KIRKLEES METROPOLITAN COUNCIL INVESTMENT & REGENERATION SERVICE

DELEGATED DECISION TO DETERMINE PLANNING APPLICATIONS

Reference No:	2023/62/93465/W
Site Address:	14, Malvern Rise, Primrose Hill, Huddersfield, HD4 6DG
Description:	Erection of single storey rear extension
Recommending Officer:	Teresa Harlow

Officer Report.

north west elevation

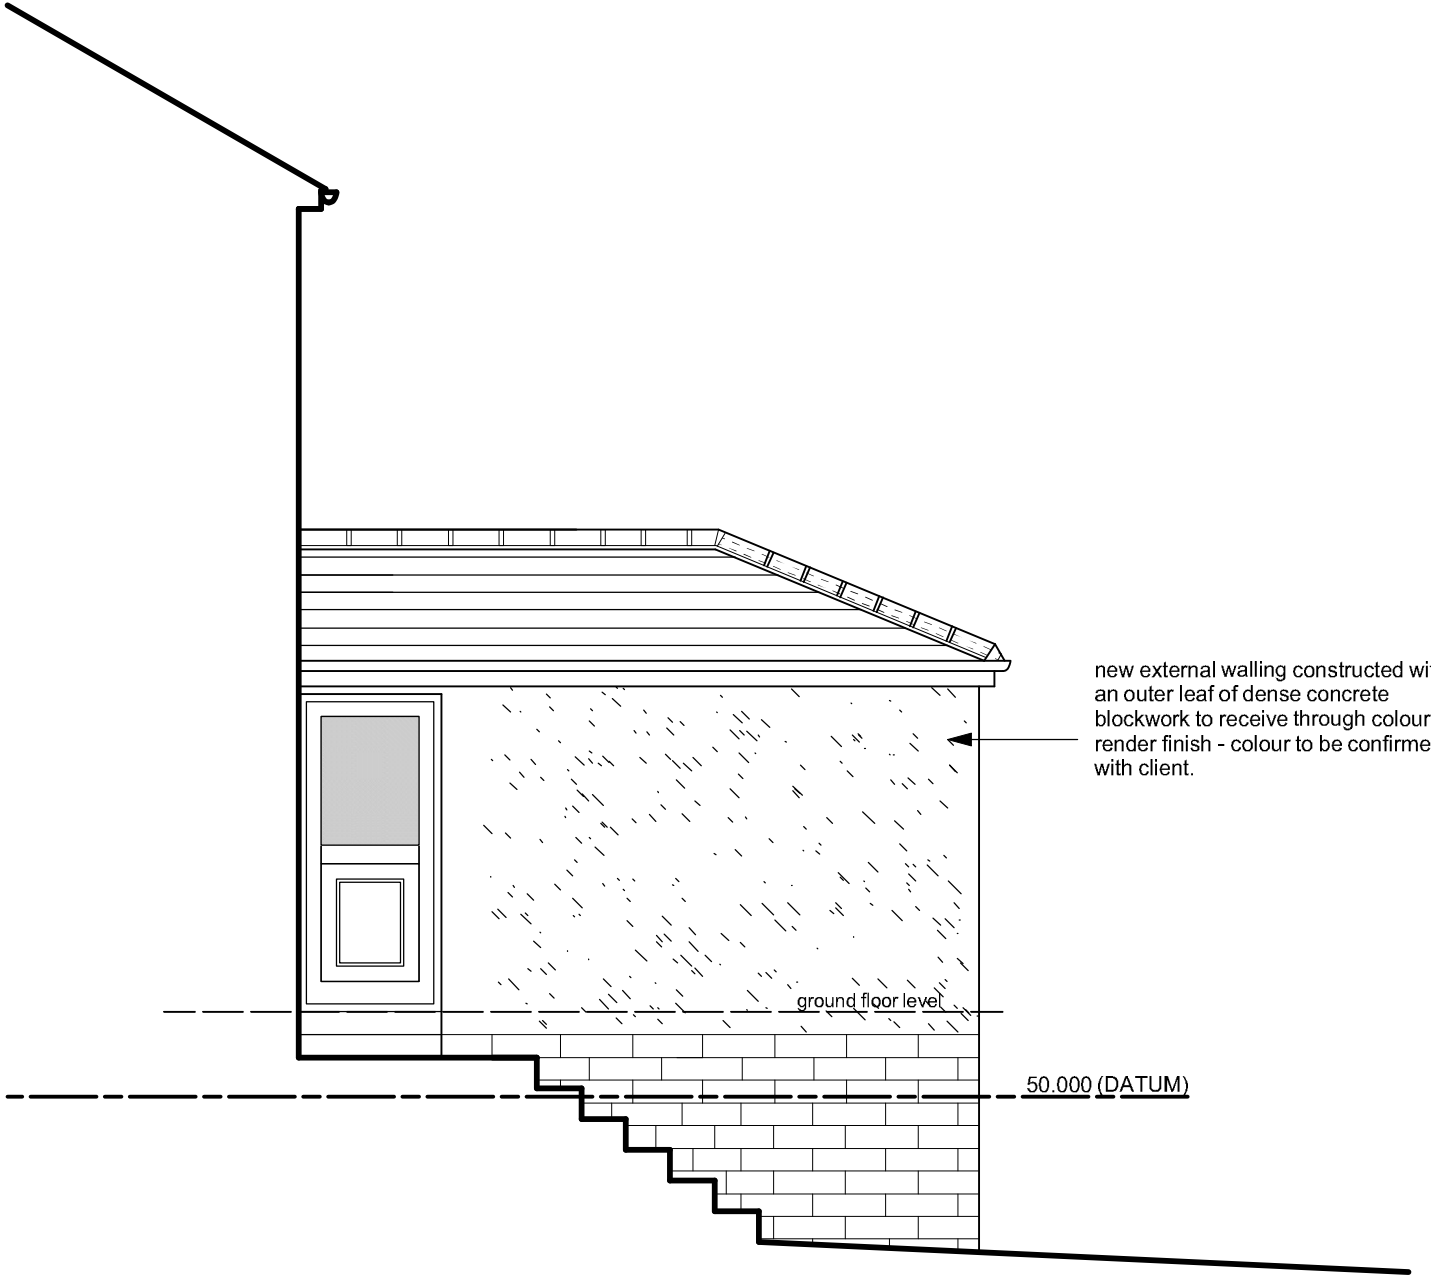
“So far as the impact of the extension on the occupiers of No. 16 is concerned, as seen from the kitchen window at No. 16 its bulk is shown by the horizontal eyeline shown in the north-western elevation and the 45-degree angle on both the proposed ground floor plan and the roof plan.

It is evident that the ridge of the extension will barely be higher than the eyeline and outlook at a 45-degree angle will barely be interrupted.

ground floor plan

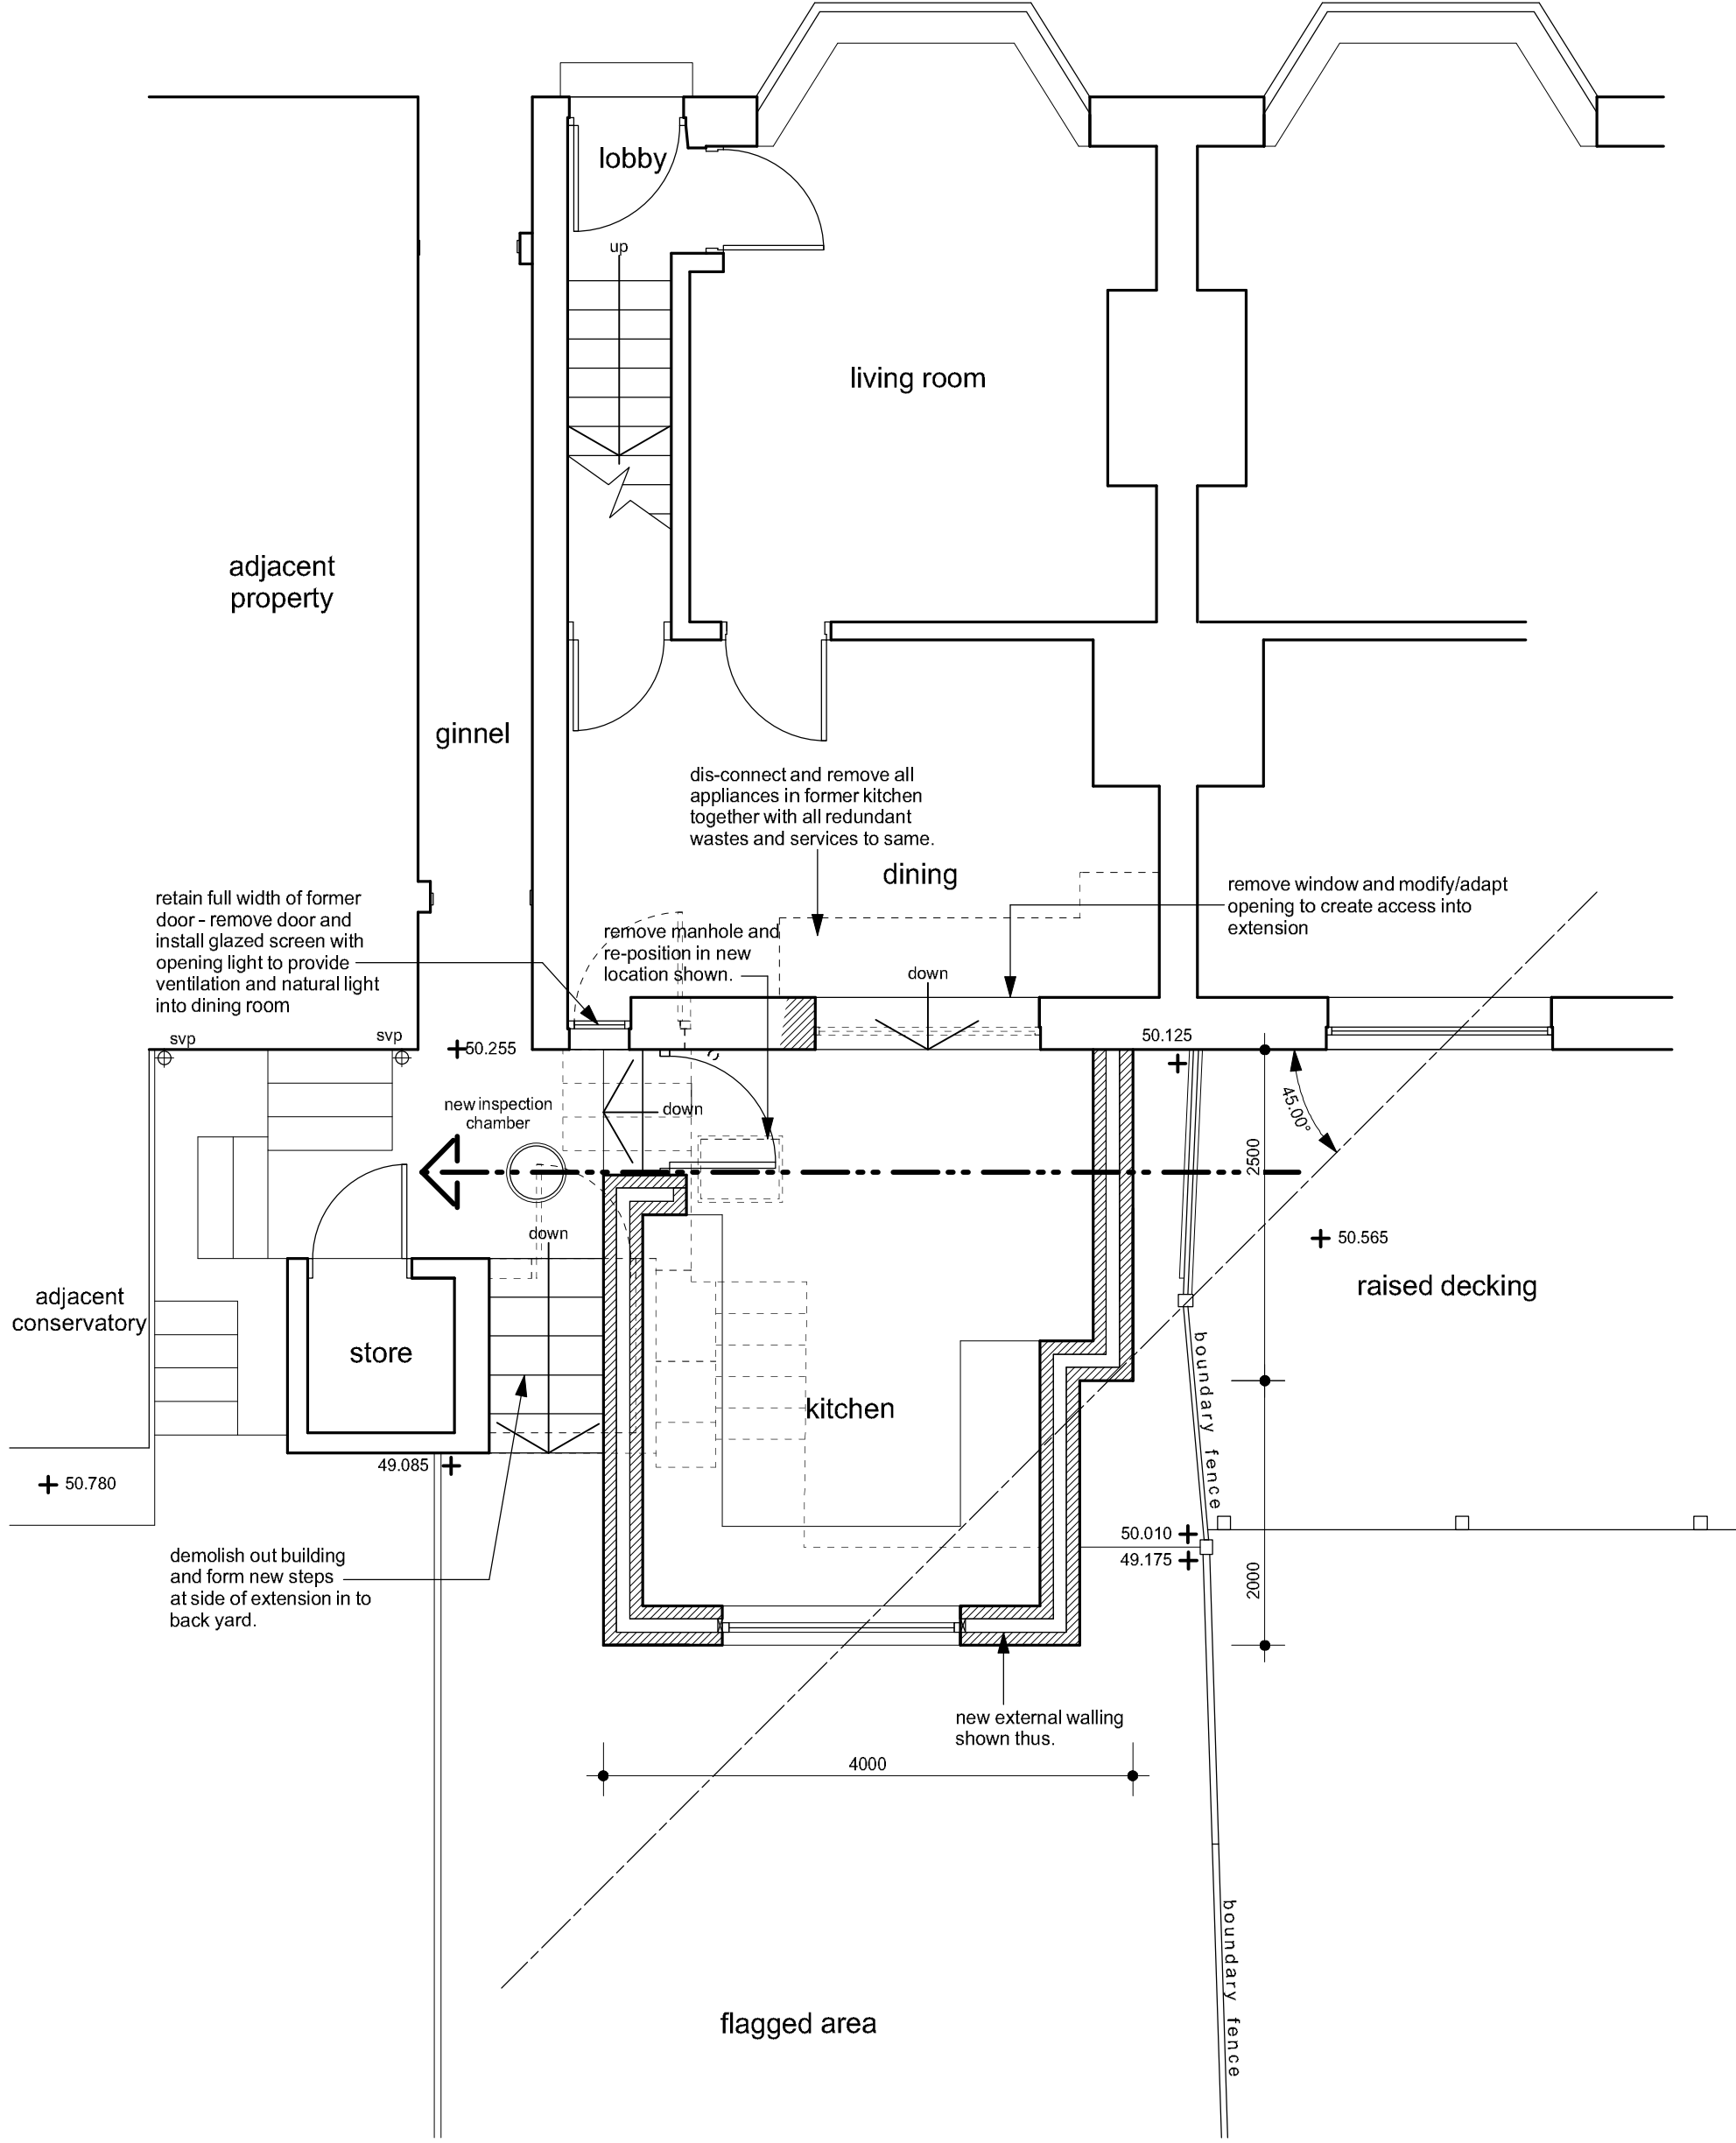
The principal deviations from the SPD are that the extension is great than 3m in rear projection (at 4.5m) and does not have a 1m gap to the fence with no. 16. It is around 0.4m.

The proposed rear extension to No. 14 Malvern Drive would now comply with the 45-degree rule as set out within Key Design Principle 5 of the SPD when a line is drawn from the midpoint of the rear conservatory at No. 12. The affected windows are in the side elevation: with the rear windows and glazed roof still provided ample daylight to the rear of no 12.

As a starting point at Section 4.17 of the SPD the 45-degree angle from a neighbouring window is set out as a guideline. Though the proposal marginally fails to meet that guideline in respect of the impact on No. 16, it is considered that the lower height of the extension compared with the internal floor level at No. 16 is such that undue impact because of loss of light and outlook is avoided.
